From: Richard Castro-Parker
Sent: 30 August 2019 12:03
To: Laura Gibbons
Cc: Daniel Vick
Subject: RE: BE/139/18/PL - Innovation Centre Beeding Close

Please see the attached PDFs of the drainage layout plan for the site re: BE/139/18/PL - Innovation Centre Beeding Close. Please could you comment on these and whether they deal with the matters you have previously raised.

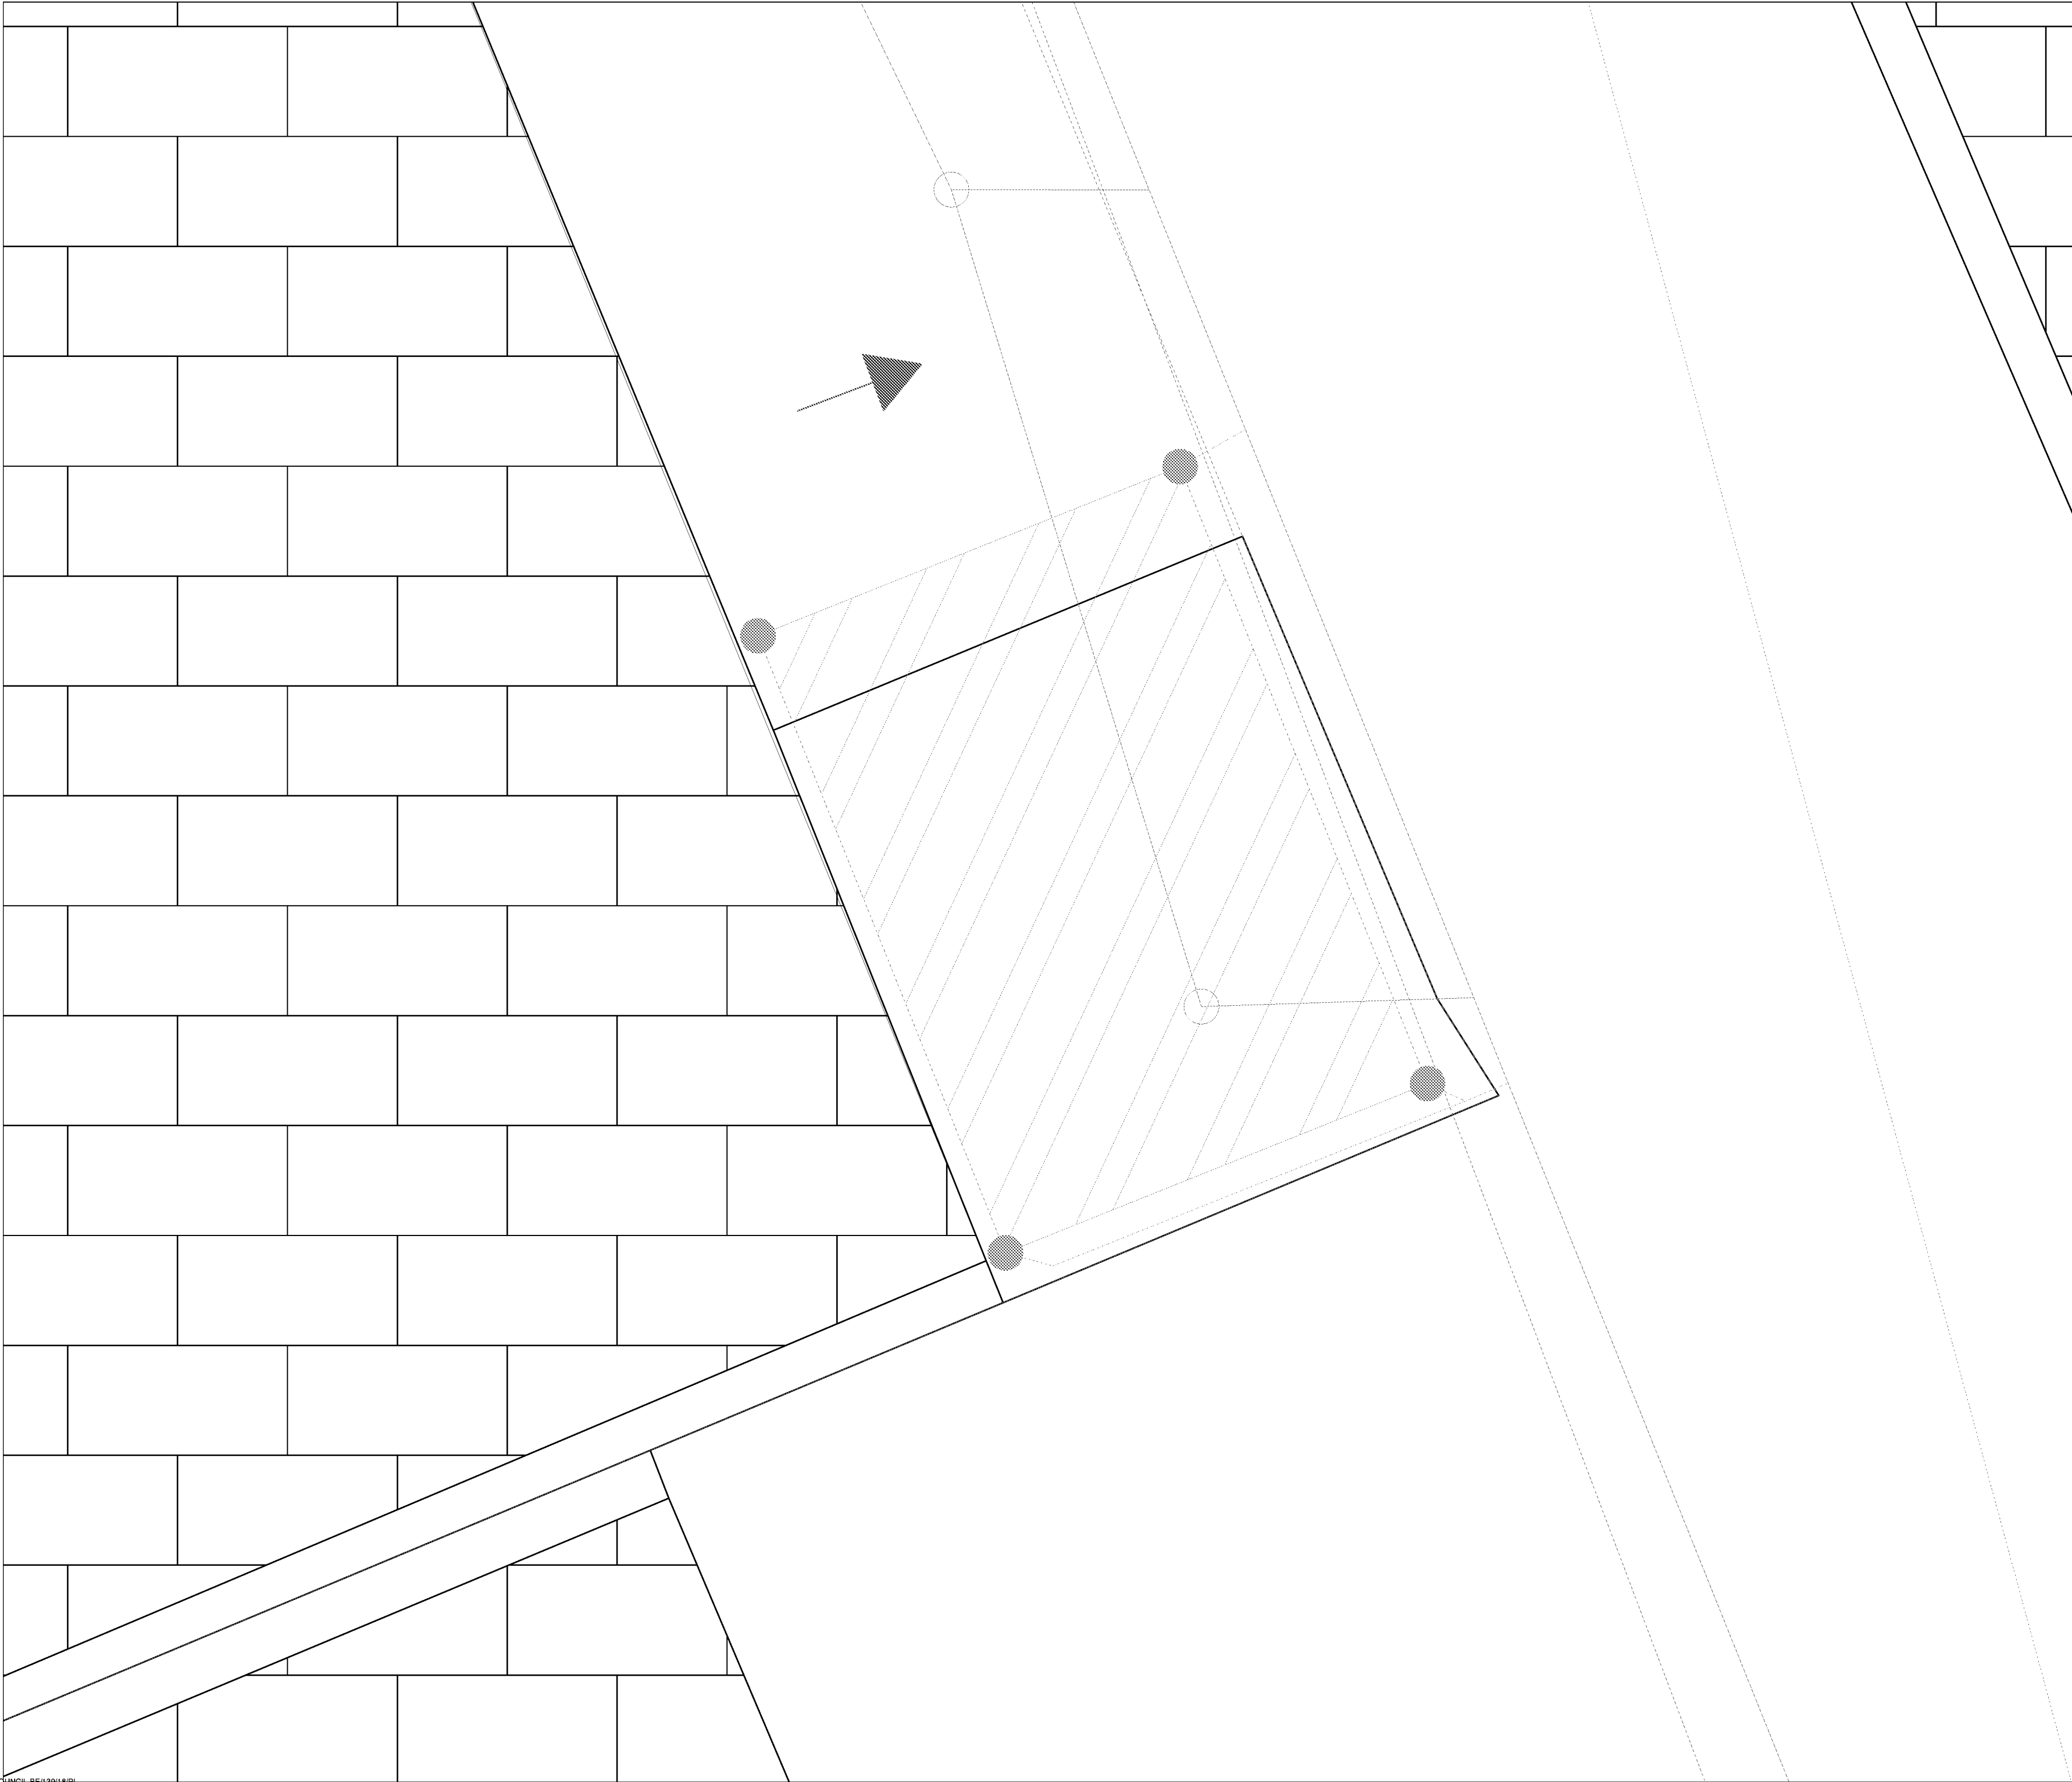
I still am struggling to distinguish between lines. Please can different line types be used, rather than all very similar colours. Please can gullies, manholes, and linear drainage channels be clearly labelled.

Regarding the levels, I also requested some spot levels of the surrounding land, can these be provided. This is fundamental to ensure that the surface water from the development does not go off site.

Please find attached a PDF of the drainage layout plan for the site. Given the size of the site, all lines on the plans are small. However, if Laura zooms in she will be able to distinguish between the pipes types. This should hopefully address her first concern.
